8 May 2020

File No: 2020/186459  
Our Ref: R/2017/25/B  
Your Ref: SSD-8924 & SSD-8925

### **The new Sydney Fish Markets – Concept and Stage 1 (SSD-8924) and Stage 2 (SSD-8925) – Supplementary Response to Submissions**

Cycling Strategy

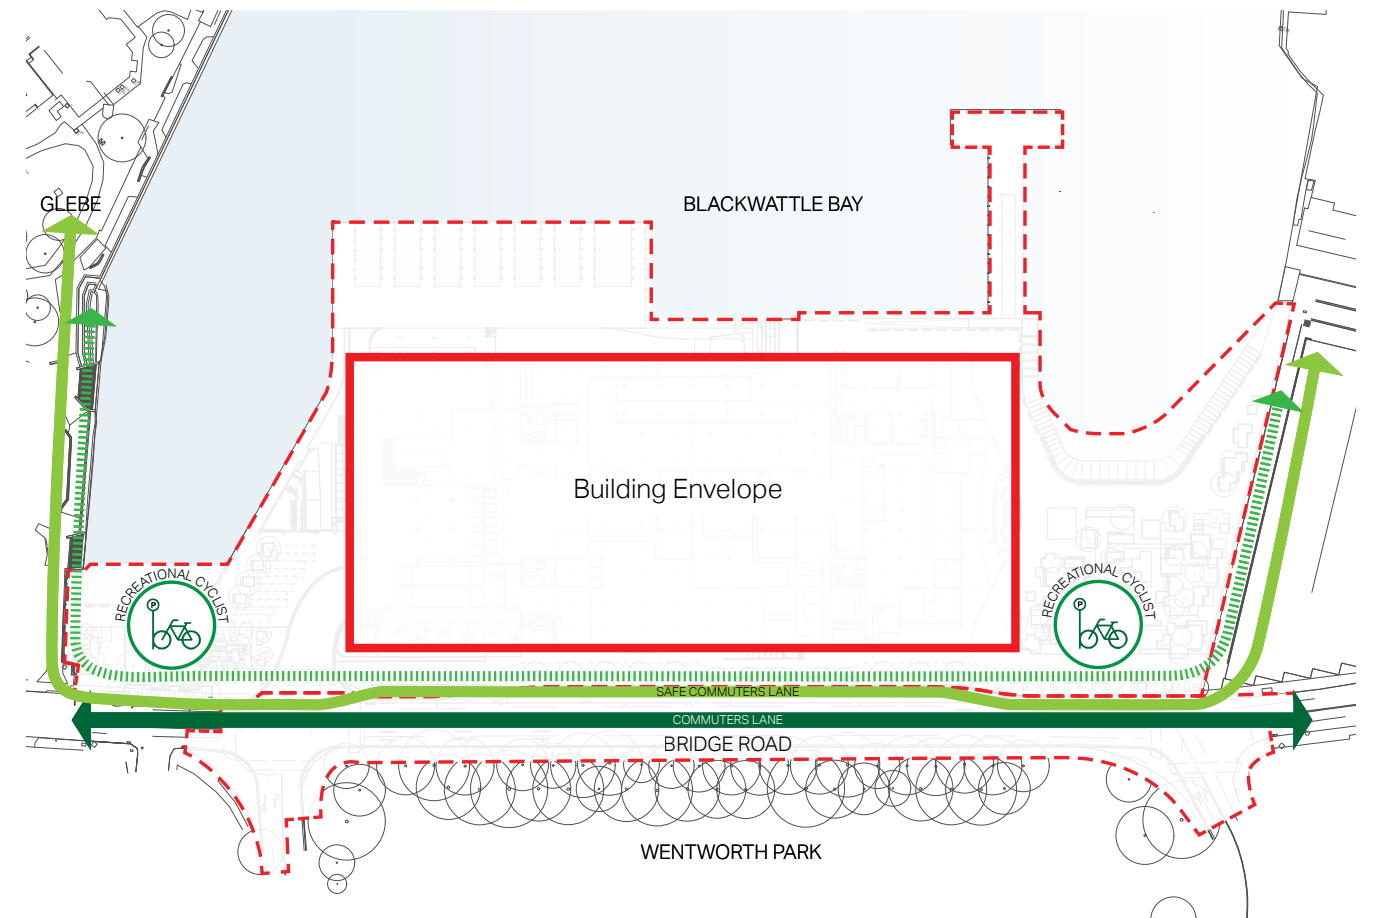
The proposed design for Bridge Road is not approved as part of this consent. Proposed “shared paths” will not be accepted. A revised design of Bridge Road that incorporates the following must be approved prior to the commencement of works:

- (a) Separated cycling facility which provides separation of bicycle movements from people walking and vehicles driving or parking on Bridge Road;
- (b) Appropriate level of coach and point to point drop off and pick up spaces; and
- (c) Space for people alighting from vehicles at the kerb side to wait adjacent to their vehicles.
